Appeal Decision

Appeal Ref: APP/R5510/D/23/3324611

69 Warren Road, Ickenham, Hillingdon, UB10 8AD

- The appeal is made under section 78 of the Town and Country Planning Act 1990 against a refusal to grant planning permission.
- The appeal is made by Mr Nathan Bunce against the decision of the Council of the London Borough of Hillingdon.
- The application Ref 13661/APP/2023/326, dated 2 February 2023, was refused by notice dated 30 March 2023.
- The development proposed is described as 'proposed extension and alterations'.

DWG. NO. 2022 / 1163 / 6^B

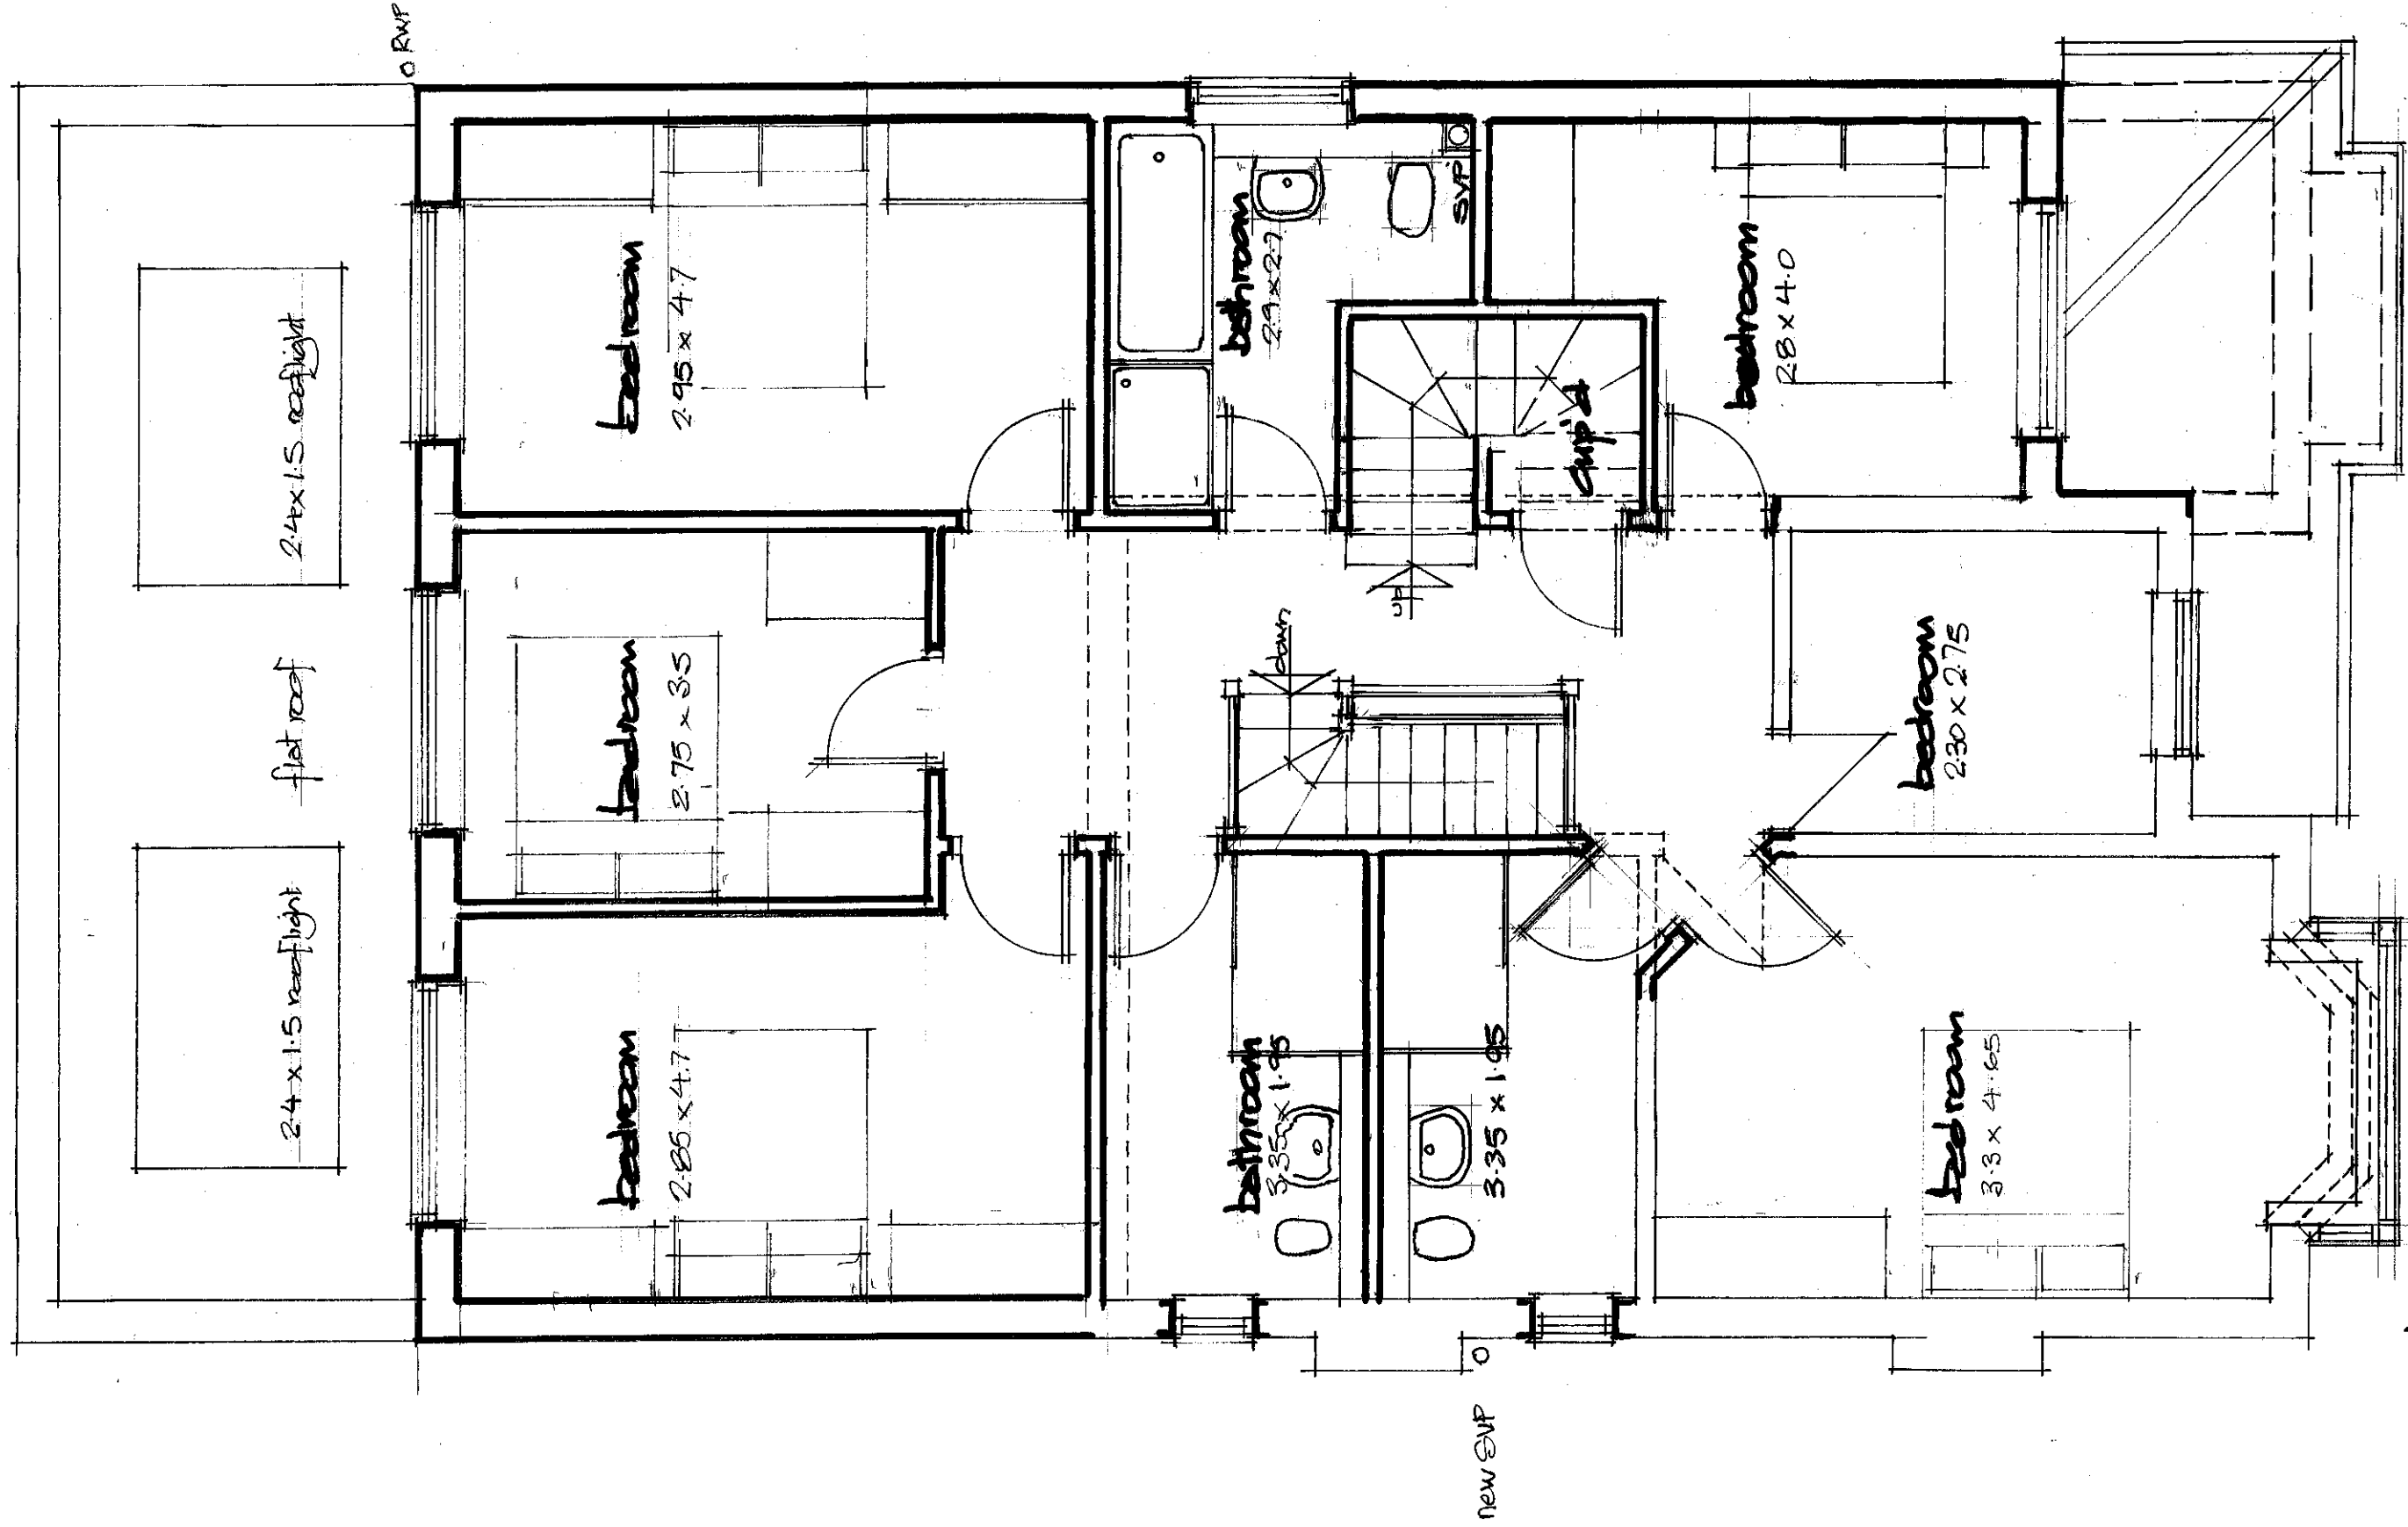
6. The proposed side extension would also have an equivalent eaves and ridge height to that of the host dwelling although it would be set back from the front elevation so that it would appear more subservient to it. However, the proposed extensions would, in my view, combine to overwhelm the modest scale of the host dwelling and would appear as disproportionately large and bulky additions that would be detrimental to its existing character and appearance. Cumulatively the proposed extensions would fail to be subordinate to the main dwelling and would be contrary to Policy DMHD 1 of the Hillingdon Local Plan: Part Two – Development Management Policies (January 2020) (LP2) in this respect.

ELEVATIONS

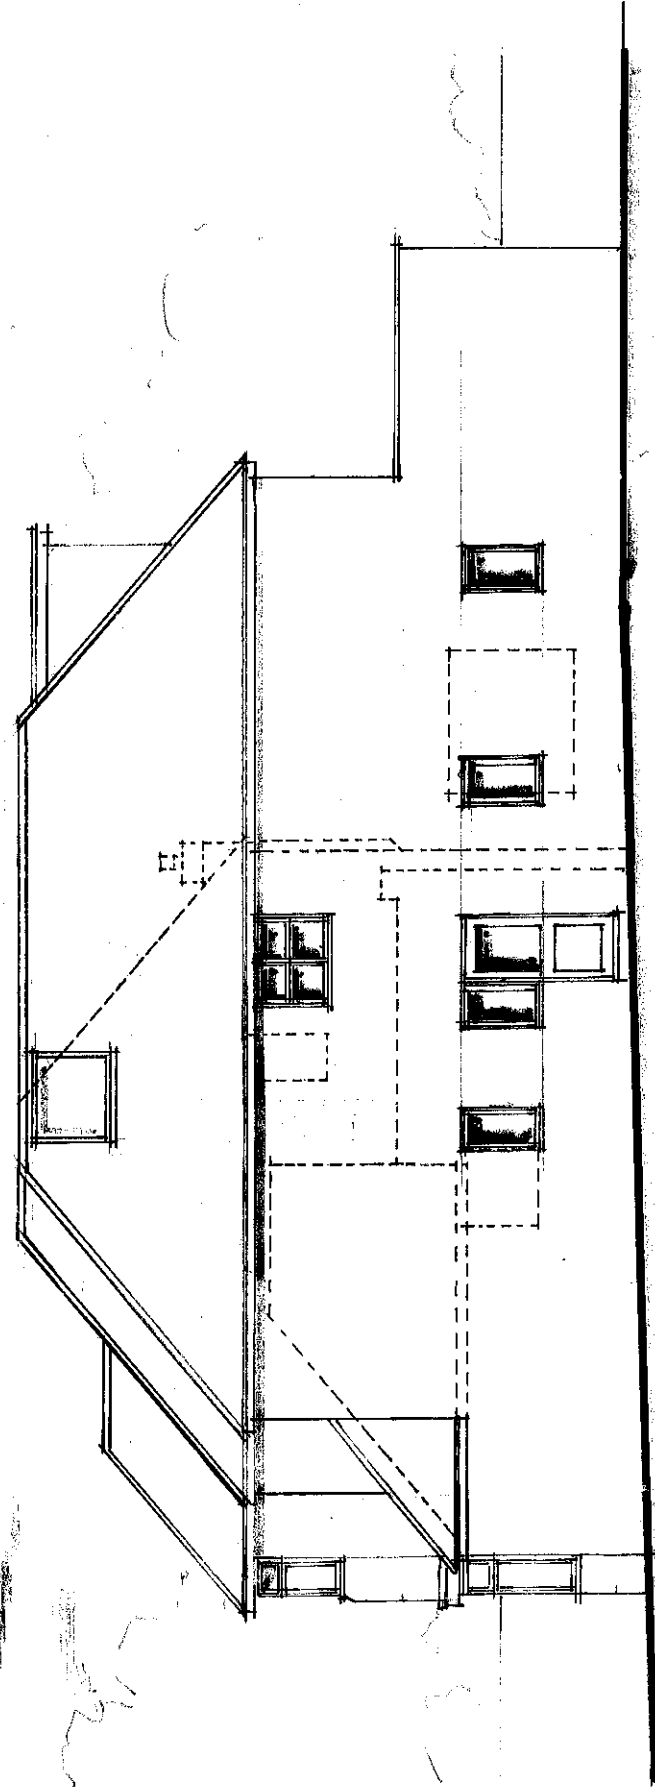
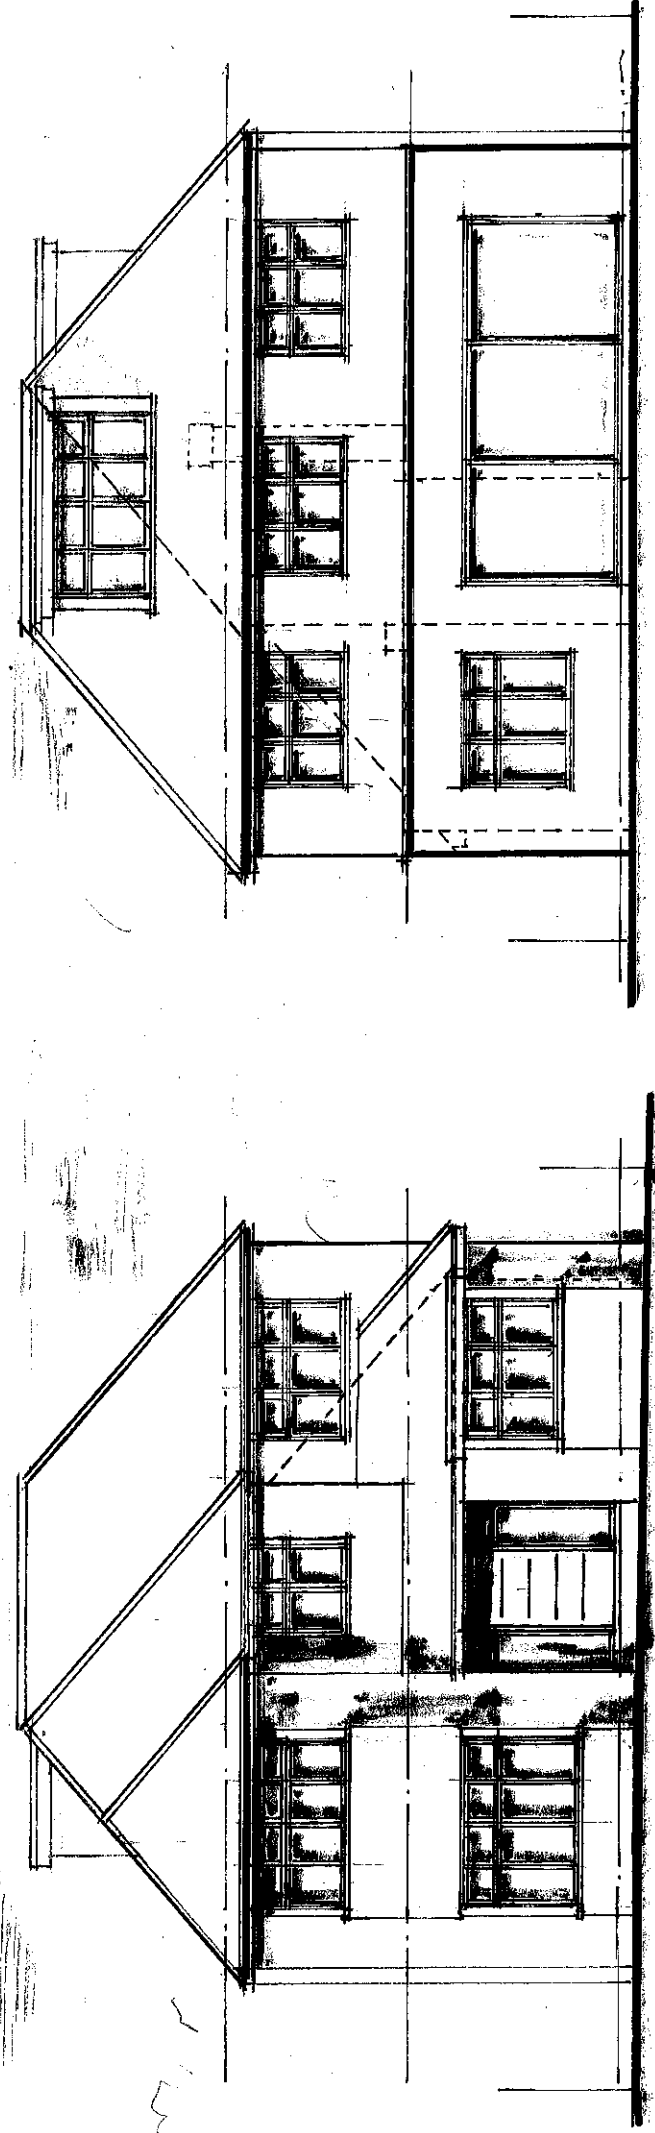
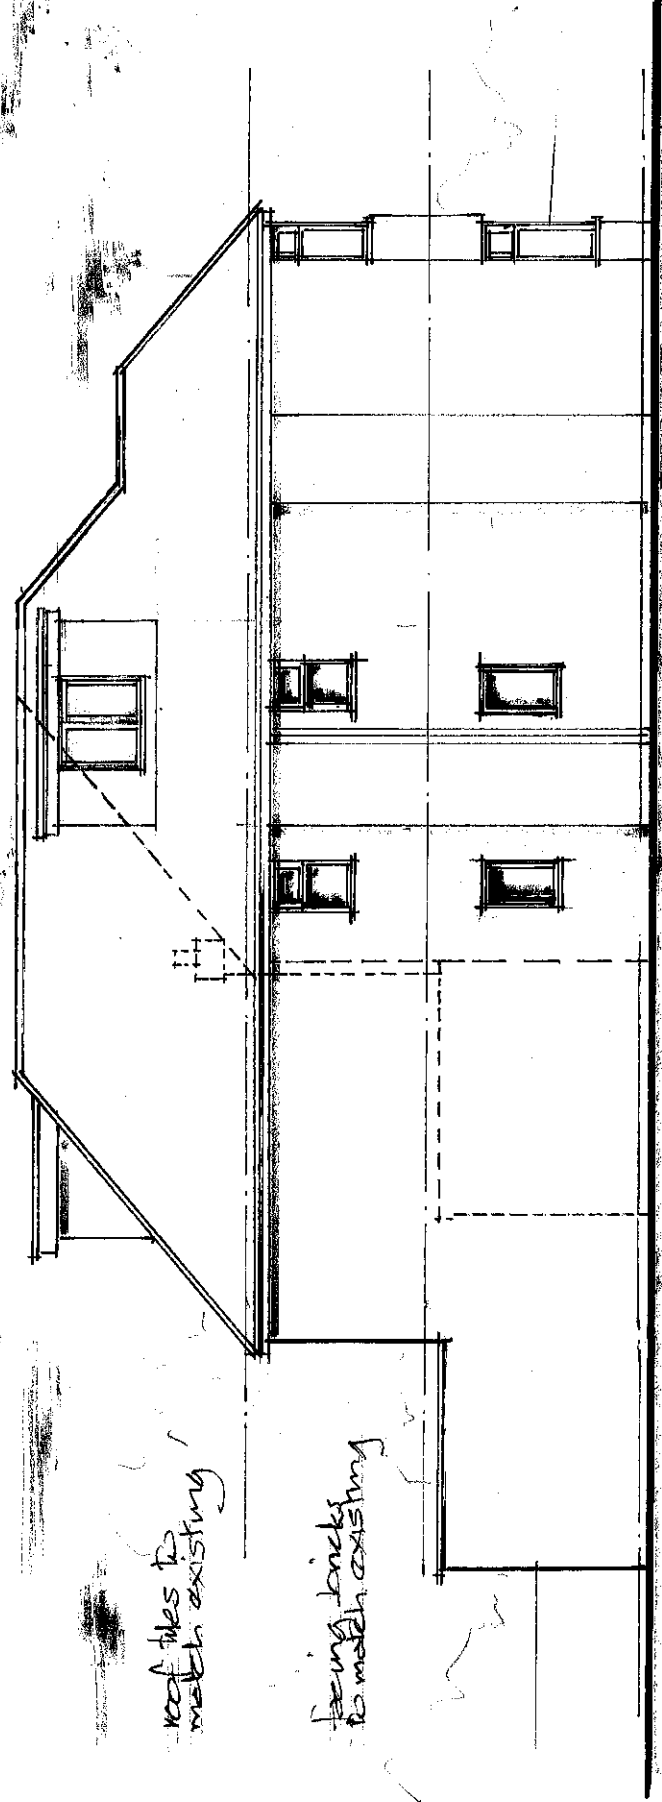
3. The appeal property is a two-storey detached dwelling with a hipped roof and a single storey addition to the side. This part of Warren Road comprises mainly of detached dwellings of a traditional design and appearance, several of which have been significantly altered and extended.
4. The appeal proposal is for a part single storey, part two storey rear extension and a first floor side extension, together with changes to the fenestration.
5. The two storey rear extension would have a depth of 5m, with the single storey extension adding a further 3m in depth. The proposed two storey rear extension would have the same eaves and ridge height as the host dwelling and given its considerable depth, would add significant bulk and mass to the host dwelling. This would be particularly apparent from the depth of the proposed flank elevations and associated bulky roof form.

7. Glimpses of the deep, largely unrelieved flank elevations would also be obtained from Warren Road, and the combined bulk and mass of the extensions would result in a dwelling that would be at odds with the modest scale and form of the adjacent dwellings, thus resulting in harm to the character and appearance of the surrounding area.

9. I also acknowledge the presence of crown roofs on several nearby dwellings and accept that the appeal proposal would not be out of keeping with this part of Warren Road in this regard. However, the overall depth, size and scale of the appeal proposal would result in particularly bulky and disproportionate additions to the dwelling which would be at odds with and harmful to the existing character and appearance of the surrounding area.

15. There is a side facing first floor window on the flank elevation of 71 Warren Road which the Council state serves a bedroom. Whilst I have no substantive evidence that this is the case, the window appears to be clear glazed and is therefore likely to serve a habitable room. The proposed two storey extensions would, in my view, be likely to result in a loss of light to this window and the deep flank wall of the two storey extension would appear overbearing and harmful to the outlook from this window. Therefore, in the absence of any substantive evidence to the contrary, I find that the proposal would have a harmful effect on the living conditions of the occupiers of No 71 in this regard.
